Application number: 2024/90339	
What is the application for?:	Erection of part two storey and part single storey front, side and rear extensio
Address of the site or building:	19, Cheviot Way, Upper Hopton, Mirfield, WF14 8HW
Postcode:	WF14 8HW

Type of comment: An objection	
Do you wish your comments to be published on the website anonymously?	Yes

PROPOSED BLOCK PLAN
1:500

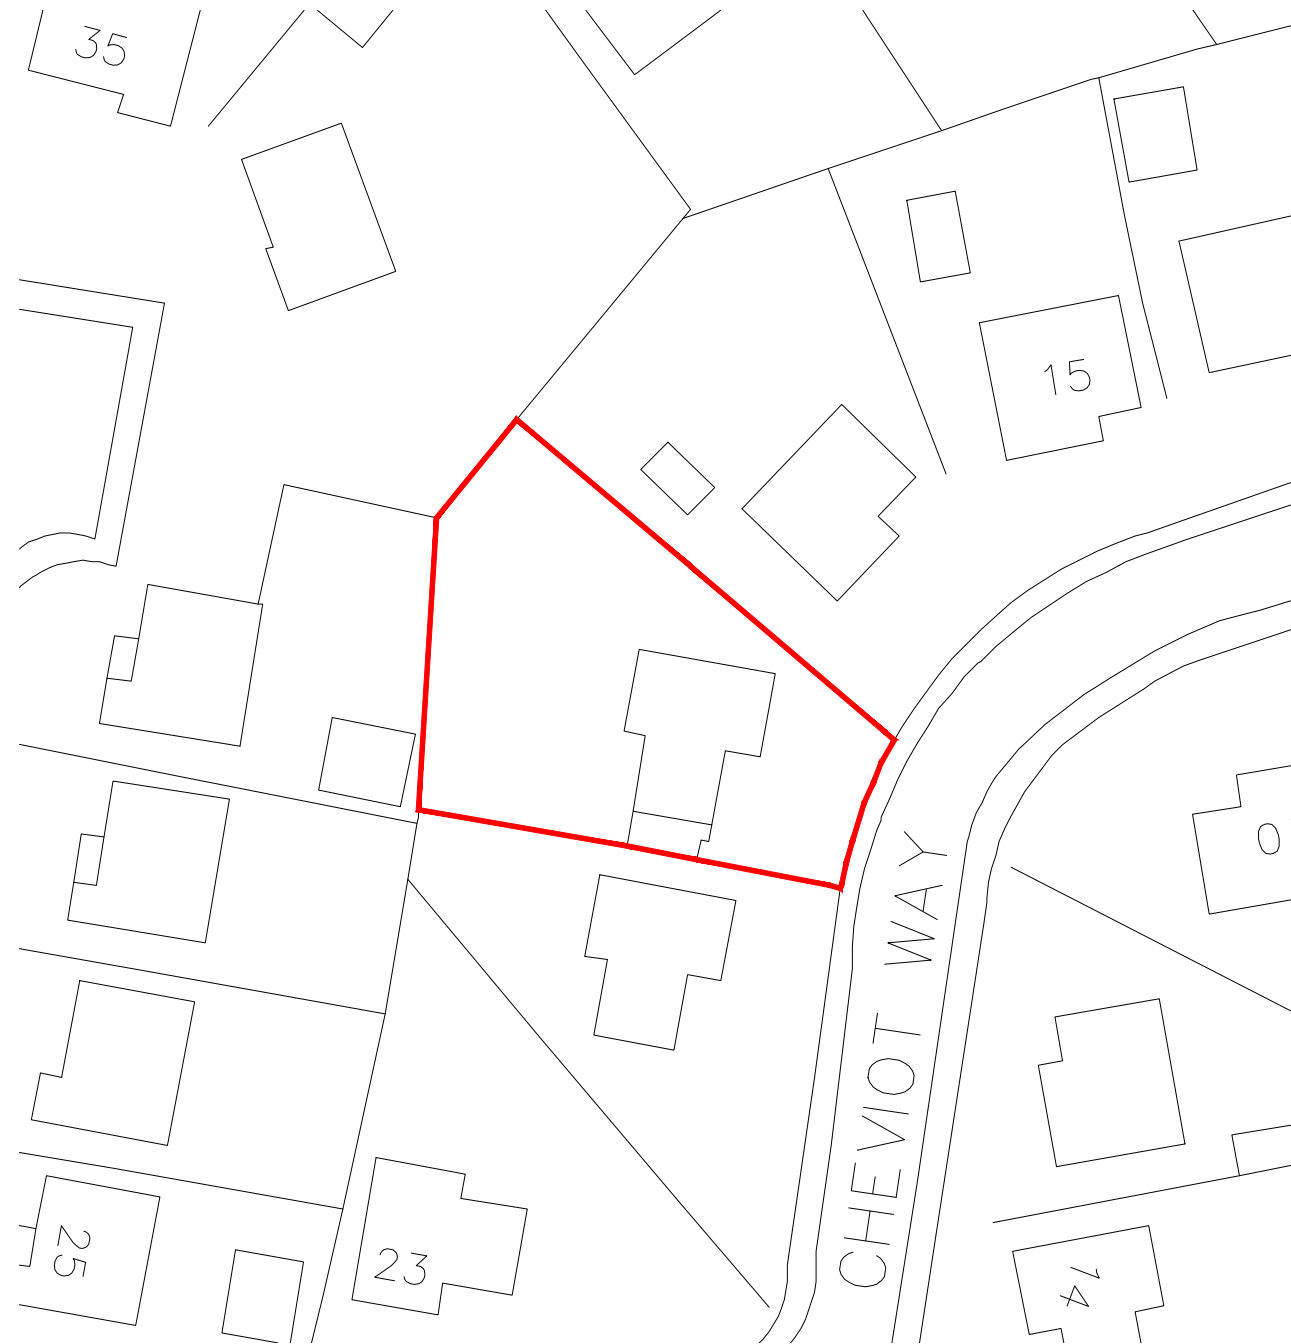
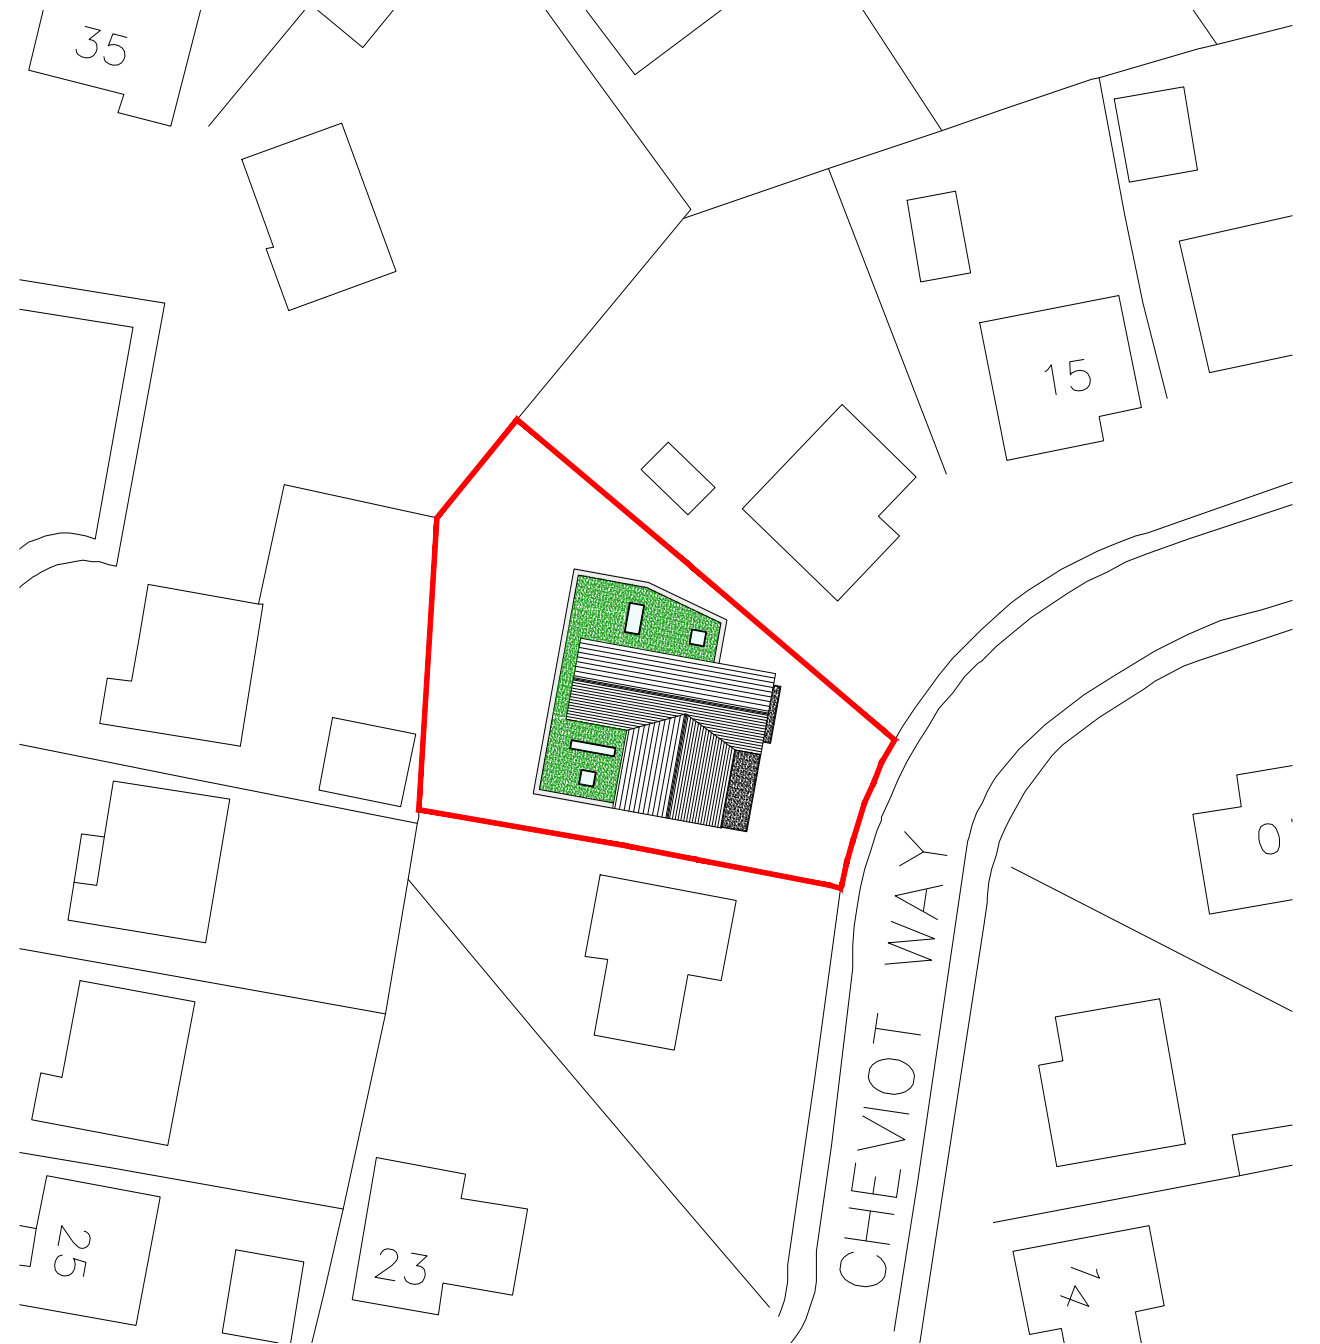
- Location plan includes car port but not the existing single storey extension on the north elevation or the rear utility room extension.
- Block plan, same as above plus does not show any vehicular access point / proposed parking layout.
